**Goulburn Base Hospital MOD 2 Design Refinements
(SSD 8667 Mod 2)**

Thank you for your correspondence via ePlanning portal (ref: PAE-724) on 14 October 2019, requesting Transport for NSW (TfNSW) to review and comment on the above modification to the subject State Significant Development (SSD 8667 Mod 2) Application.

The proposed modification includes changes to the Goulburn Base Hospital (GBH) site-layout, signage and materials to provide better public outcomes. On this note, the exhibited documents have been reviewed and the following comment is provided below.

Sheet No 20 of 34

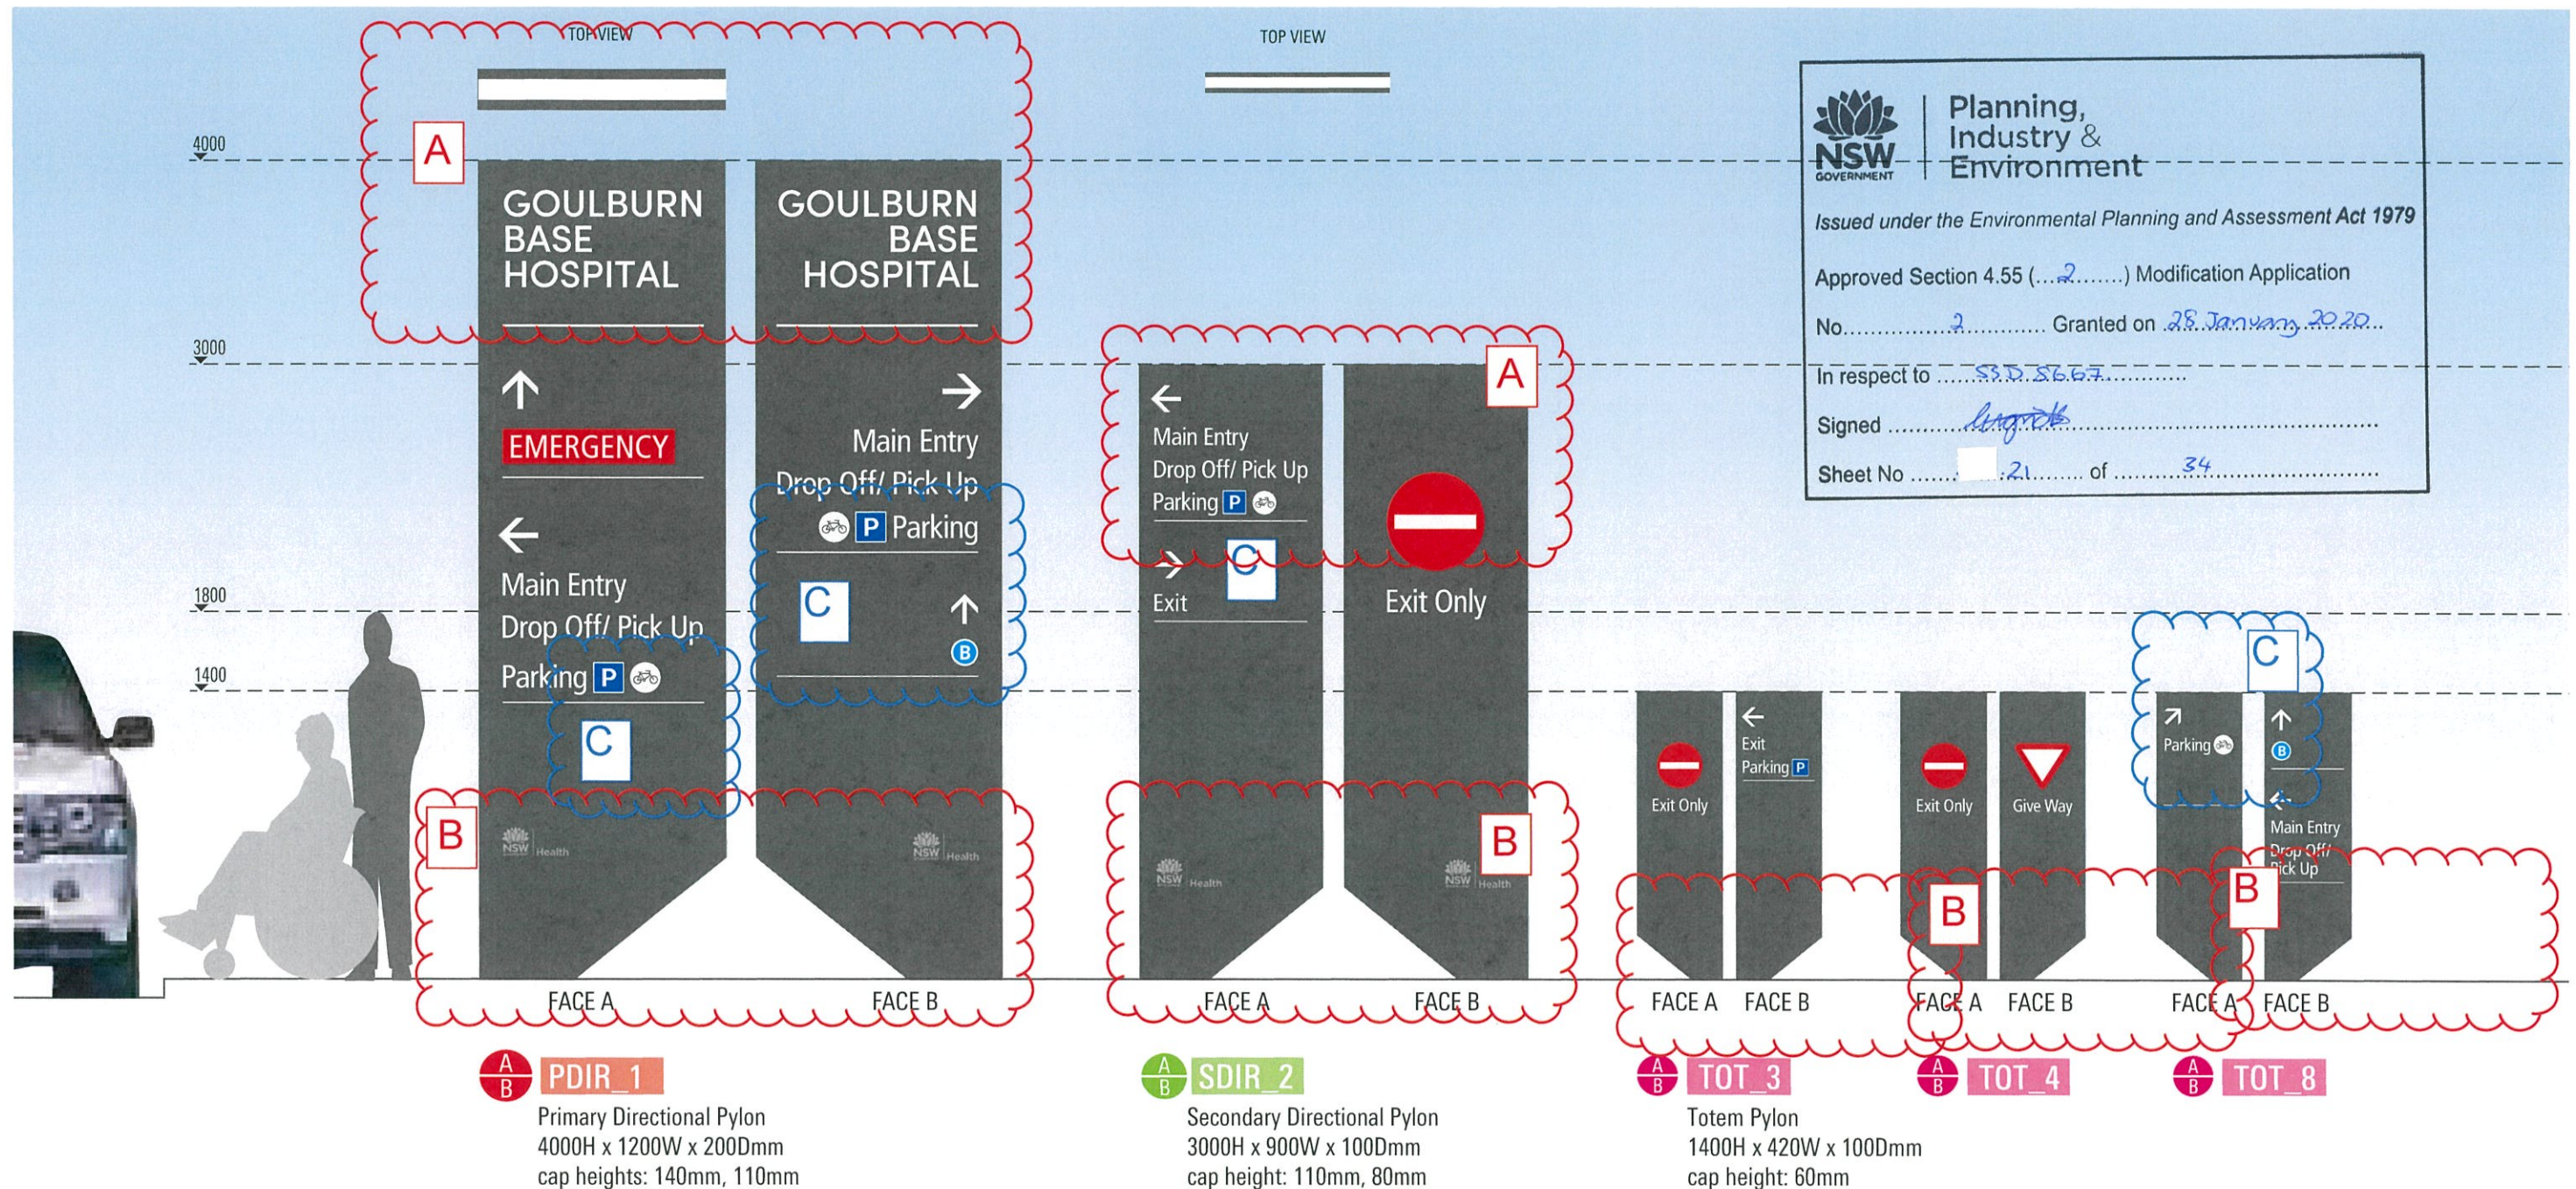
Wayfinding outcomes can be further improved by increasing awareness of public and active transport access to and from the hospital.

It is recommended to include wayfinding strategies and travel access guides along with the signage modifications to assist with increasing the mode share of walking, cycling and public transport. Regarding public transport, it is recommended that wayfinding to the nearby bus stops at Goldsmith St and Albert St is included.
